From: David Margolis-Pineo
To: Barbara Barhydt; Helen Donaldson
CC: DEVELOPMENT REVIEW GROUP
Date: 5/12/2015 4:33 PM
Subject: Review Comments - 72 Bishop St - AVESTA Housing

Memo To: Nell Donaldson
Barbara Barhydt
From: David Margolis-Pineo
Re: 72 Bishop Street – AVESTA Housing (2015-060)

The Department of Public Services has the following preliminary comments on the above mentioned site plan.

Title:
POST DEVELOPMENT STORMWATER PLAN

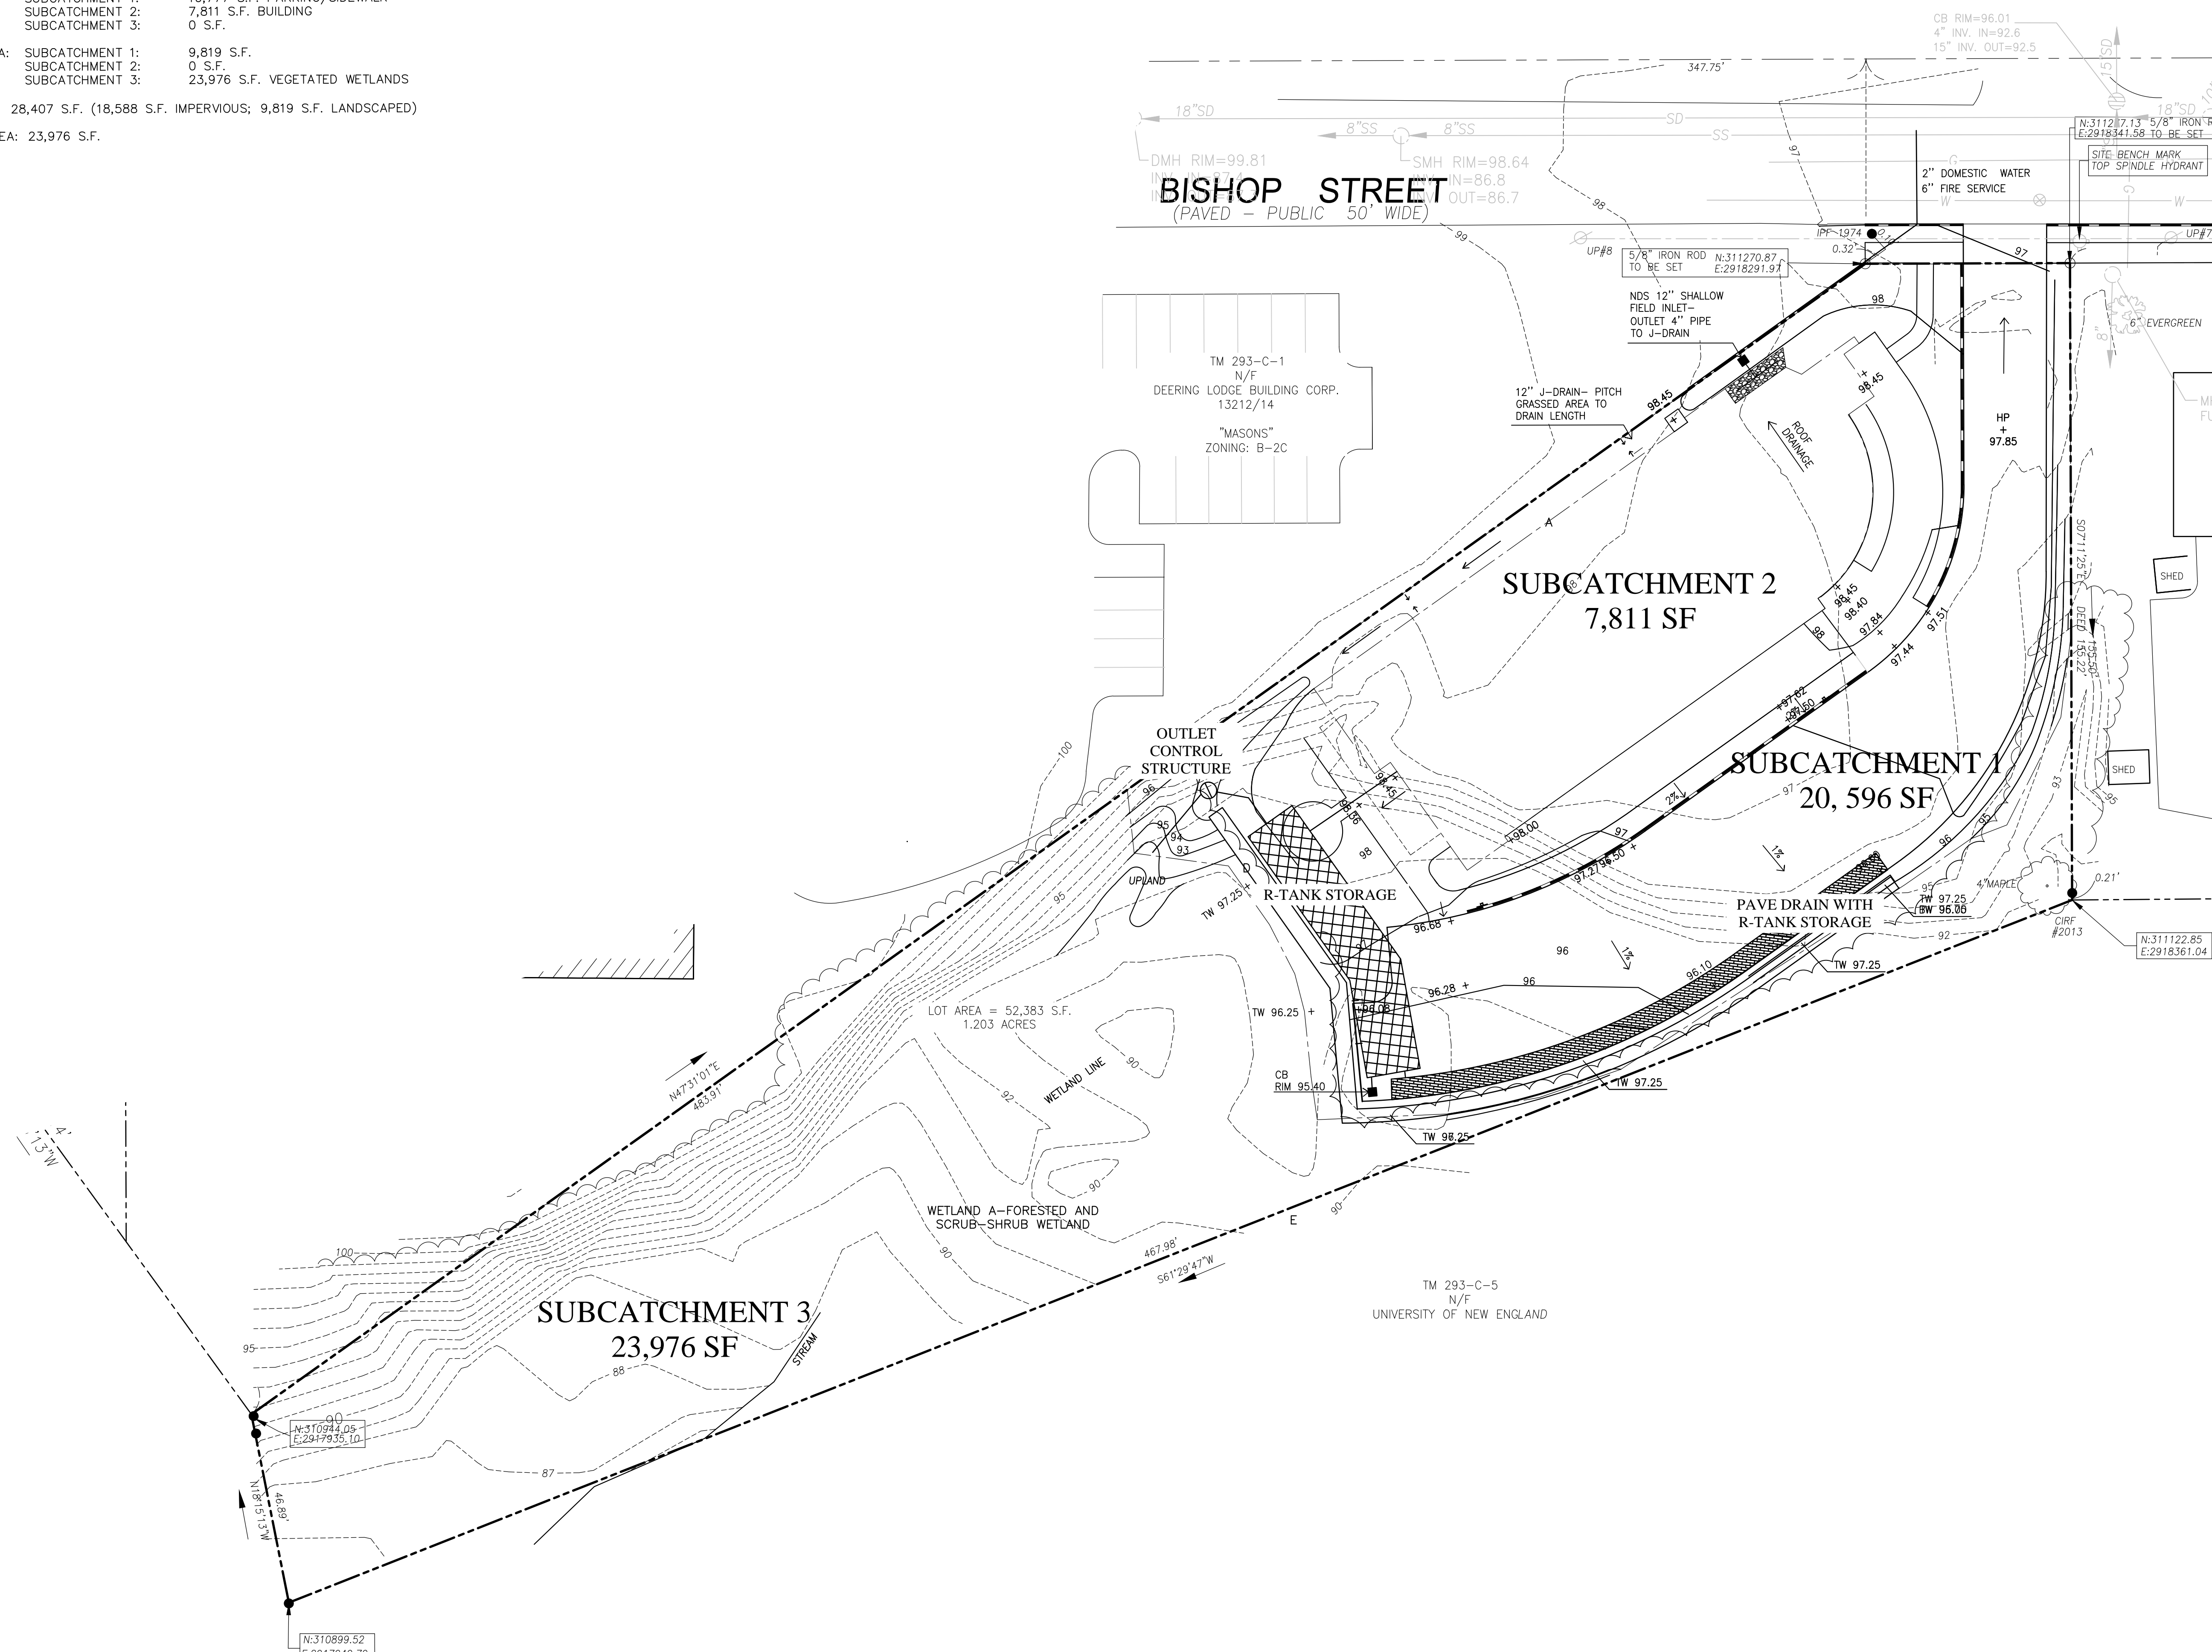
5. The grading plan needs to show the existing stormwater drainage system including drain manholes adjacent and on the applicant's property. Show all field inlets, rim elevation, pipe size and pipe invert elevations.

9. All catchbasins capturing stormwater discharging into an urban impaired watershed, the applicant is requested to install four foot diameter catchbasins with three foot sumps.

BOUNDARY & TOPOGRAPHIC SURVEY
AT
72 BISHOP STREET, PORTLAND, MAINE
MADE FOR
AVESTA HOUSING
307 CUMBERLAND AVENUE, PORTLAND, MAINE

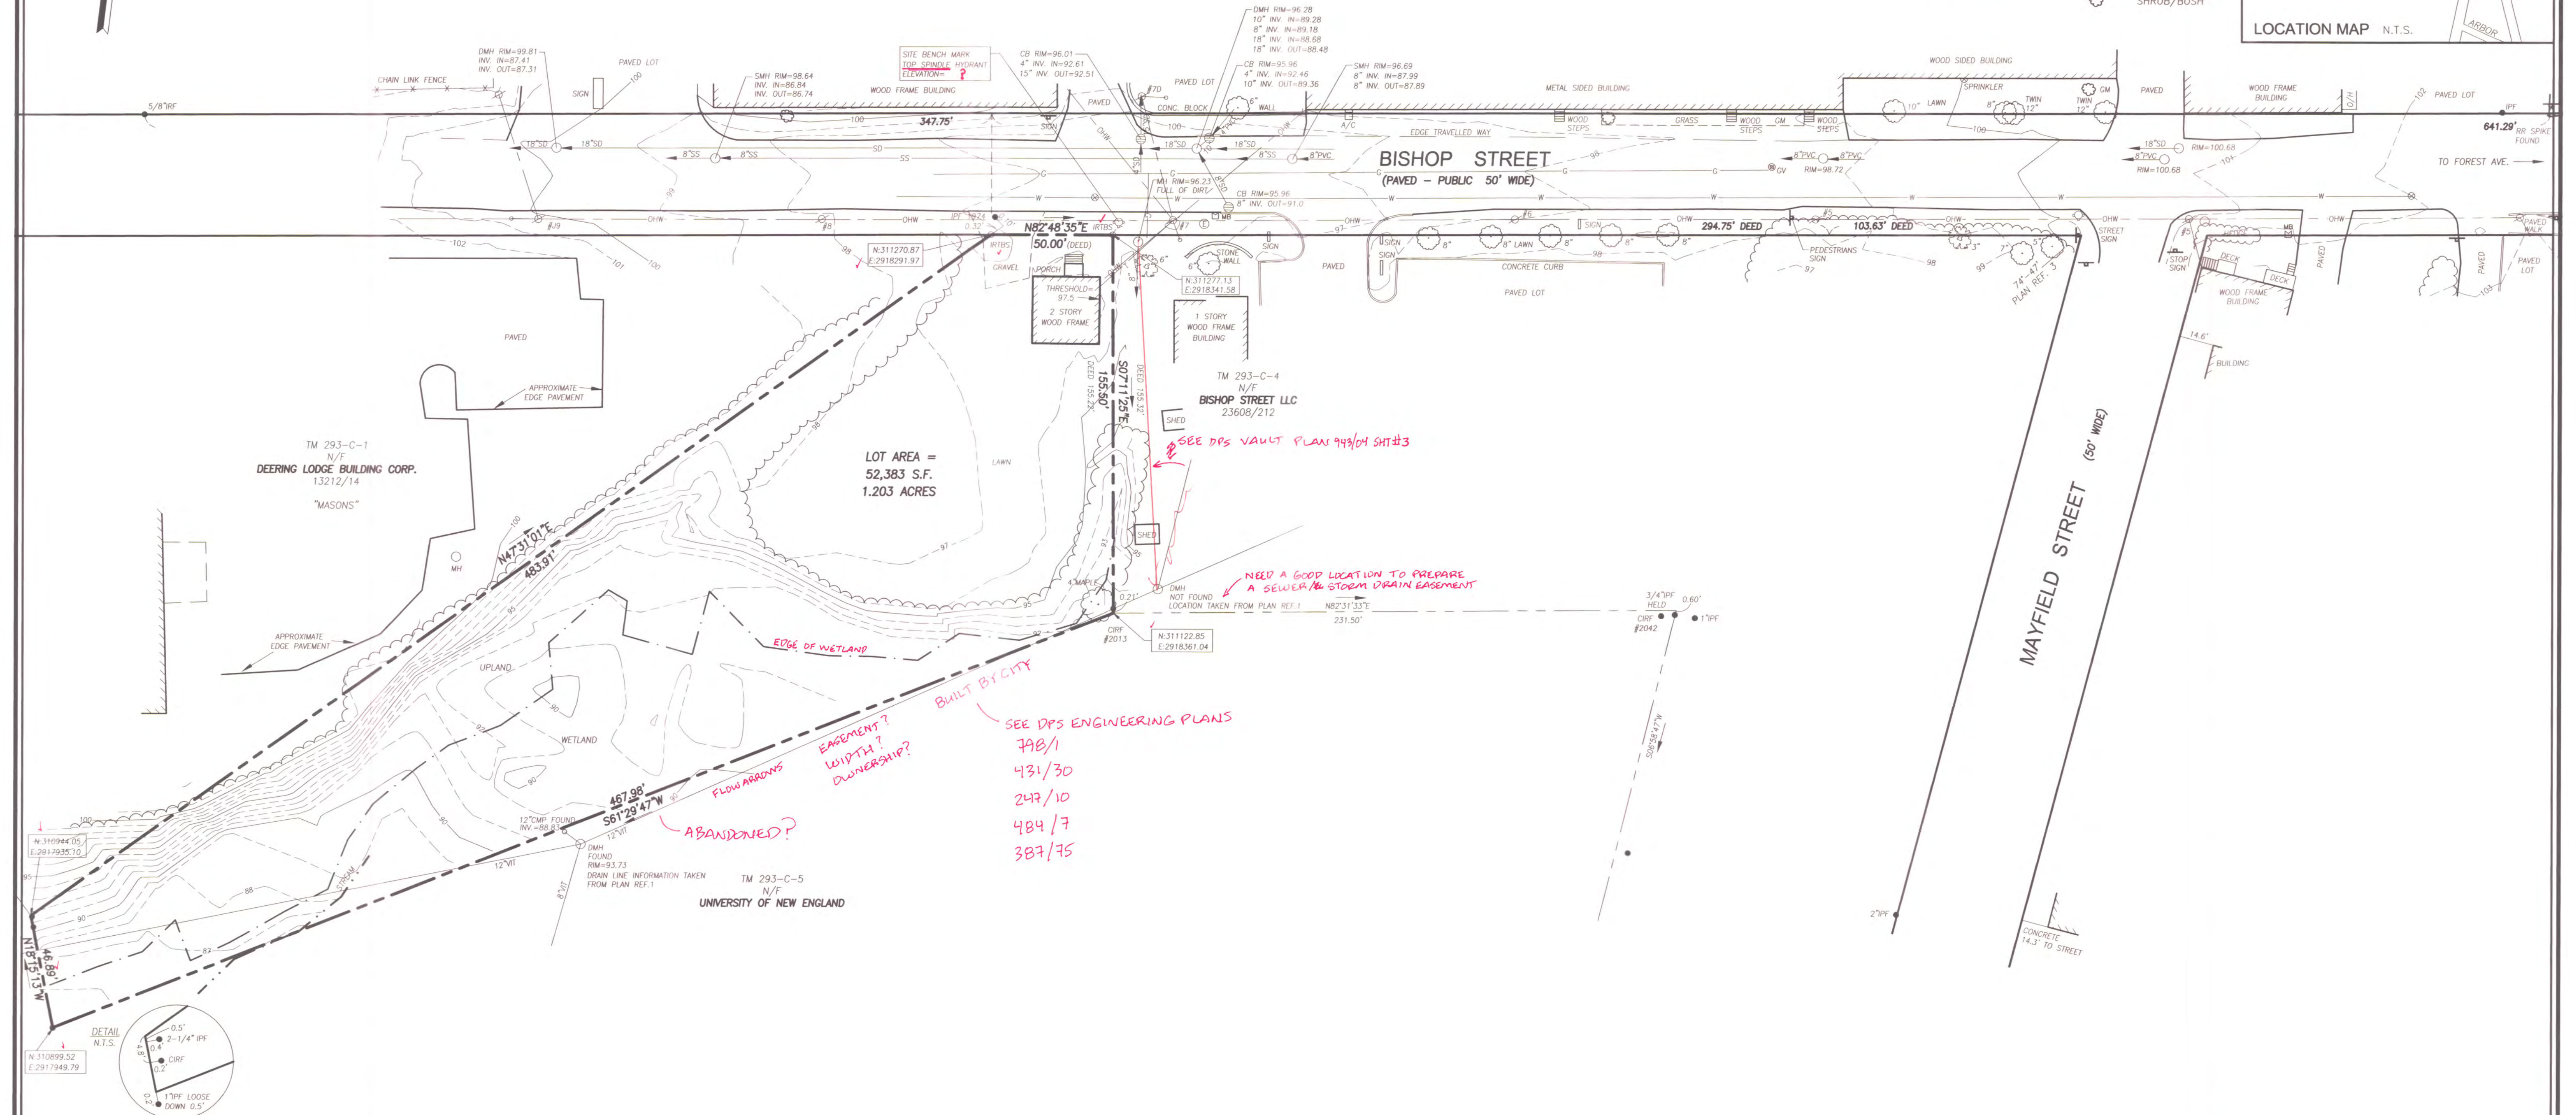
1. Surveying comments will be forwarded by William Clark of this office under a separate cover. Survey plan will require a Professional Surveyor stamp.

4. An existing stormwater drain is shown crossing the applicant's property. An easement will need to be shown on the survey plan for this utility. For an accurate easement, the cross-country drain manholes will need to be located. If necessary, the City can assist with locating.

Title:
EXISTING CONDITIONS & DEMOLITION PLAN

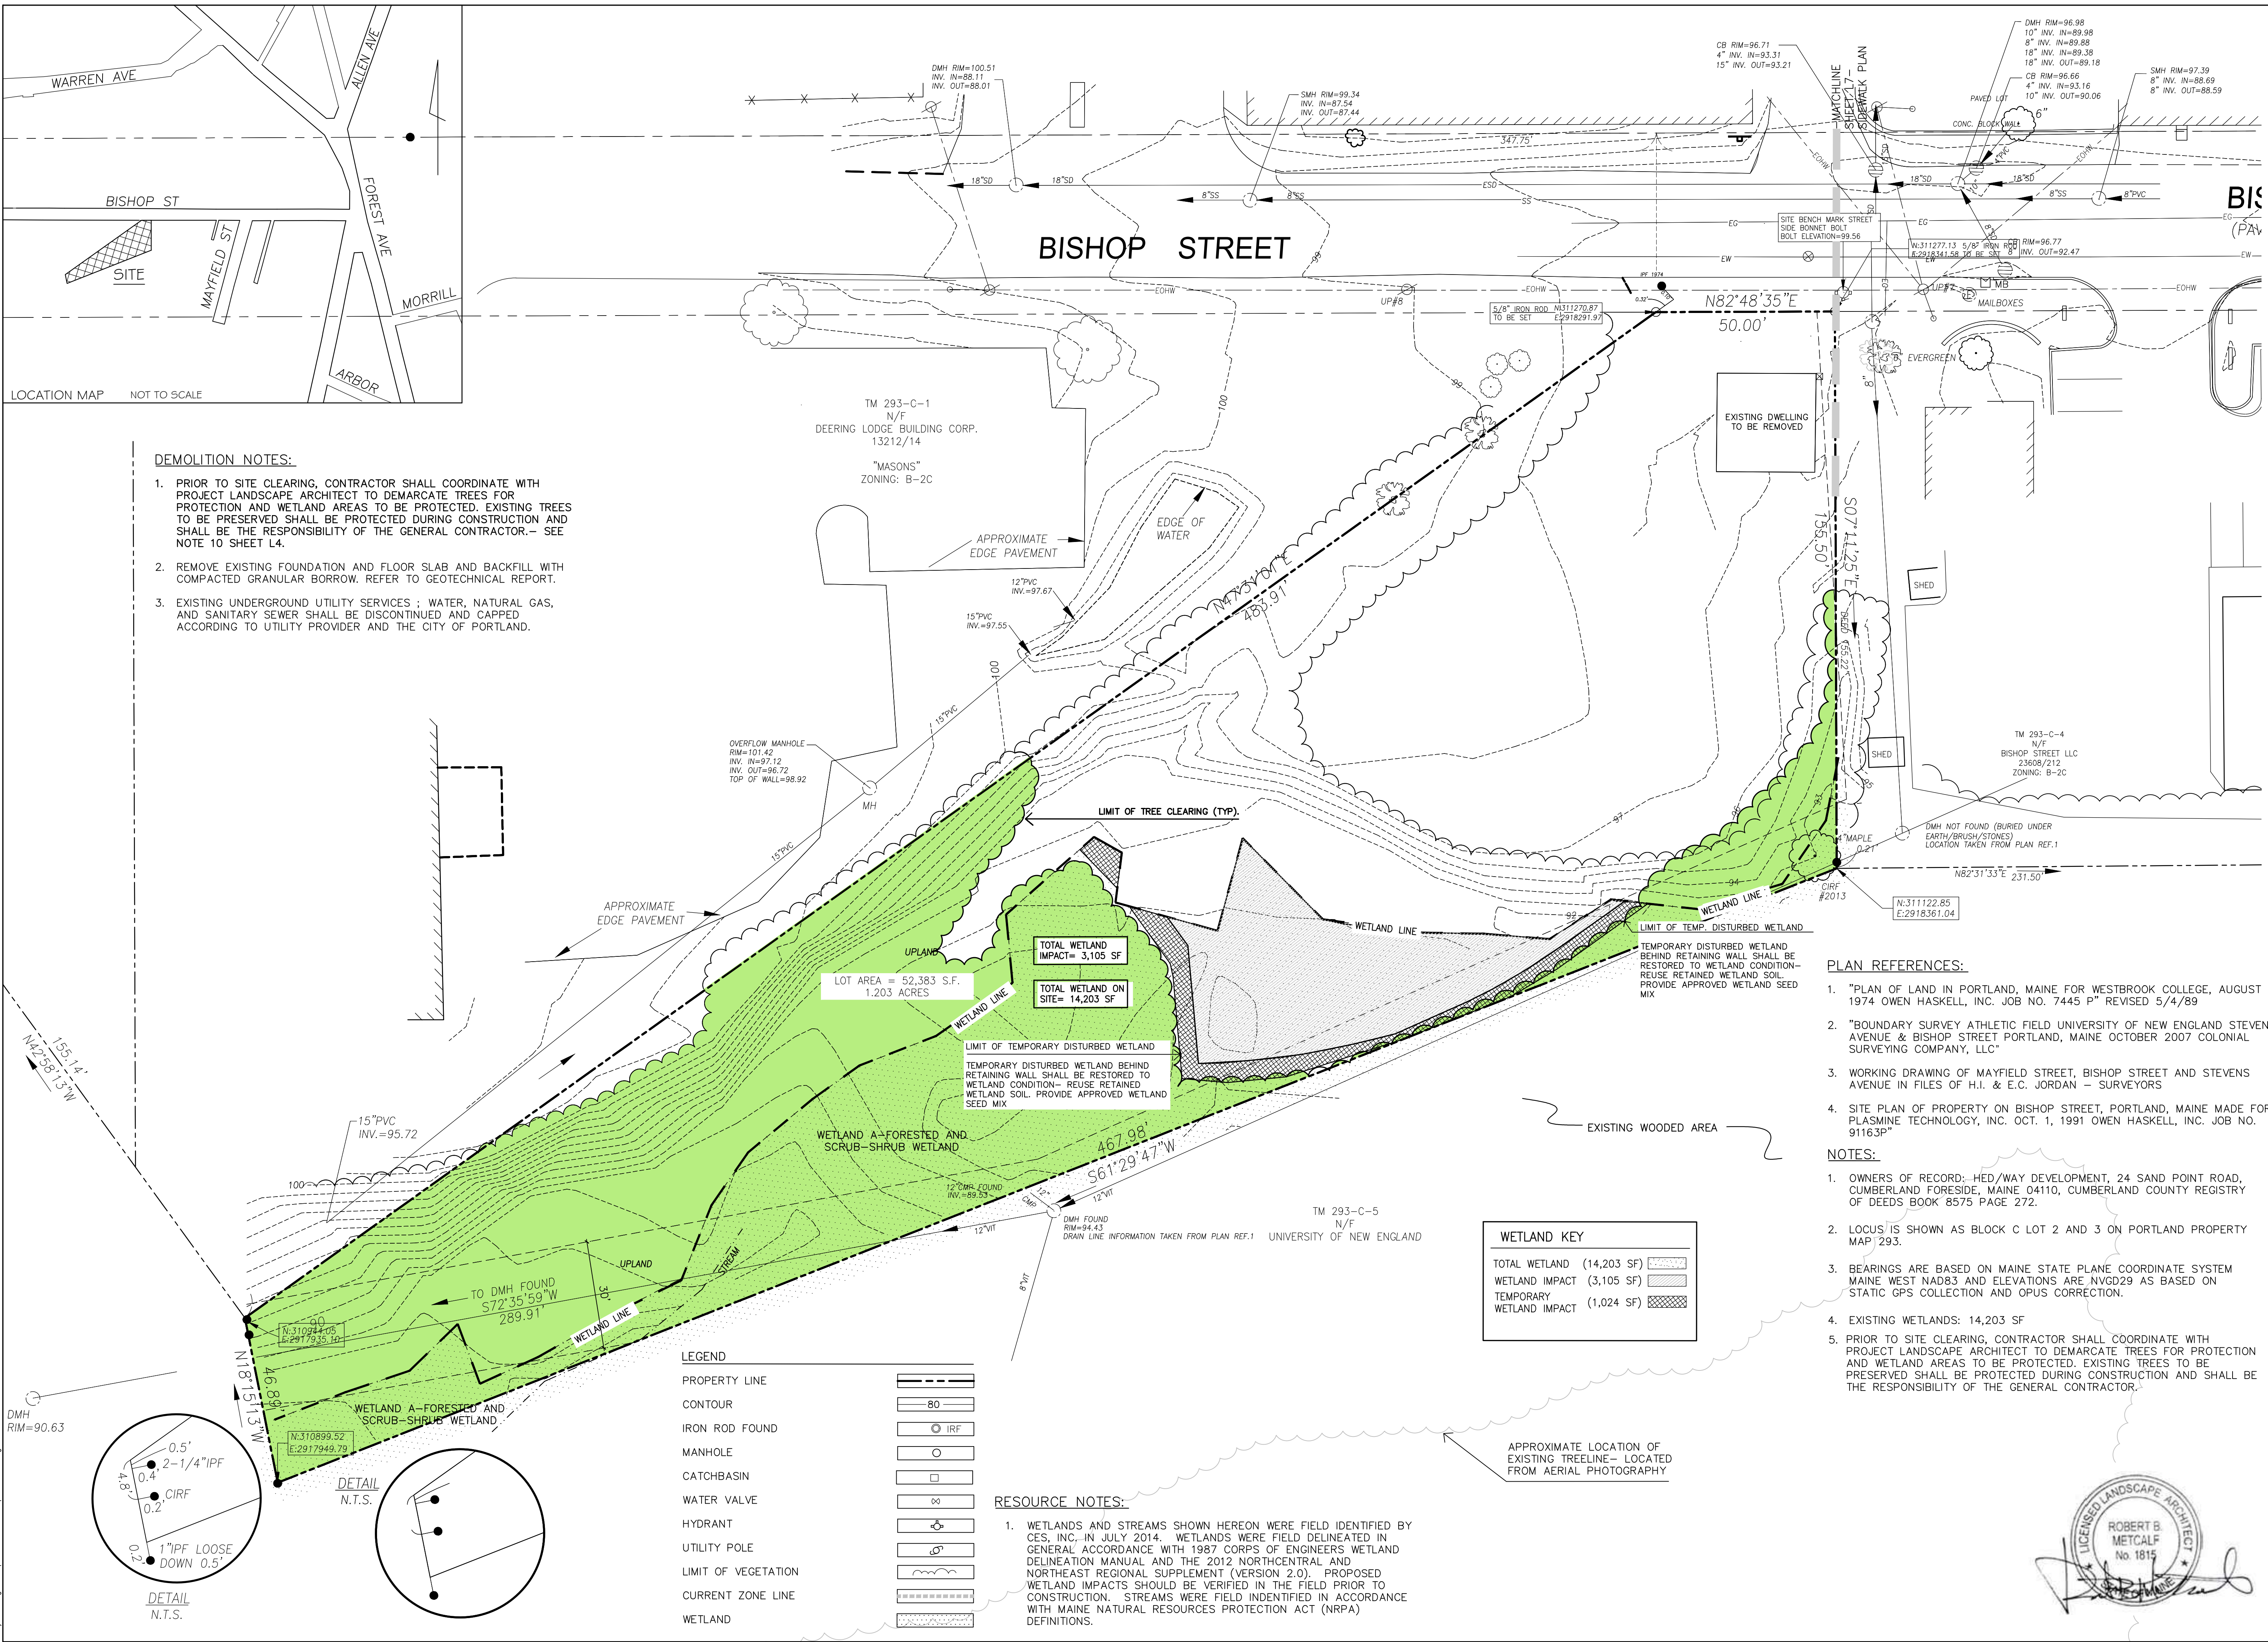
6. The applicant is indicating that an existing house on the property will be removed for this project. Please be aware that Demolition and Seal Drain Permit is required. No response required.

7. This Department has concerns regarding the wetland impacts and encroachment on the stream. We would like to see the wetland delineation line shown on the post-construction site plan to more clearly define the area of impact. A comparison of pre and post wetlands delineation is requested. Please show the limits of temporary construction activity on the wetlands area.
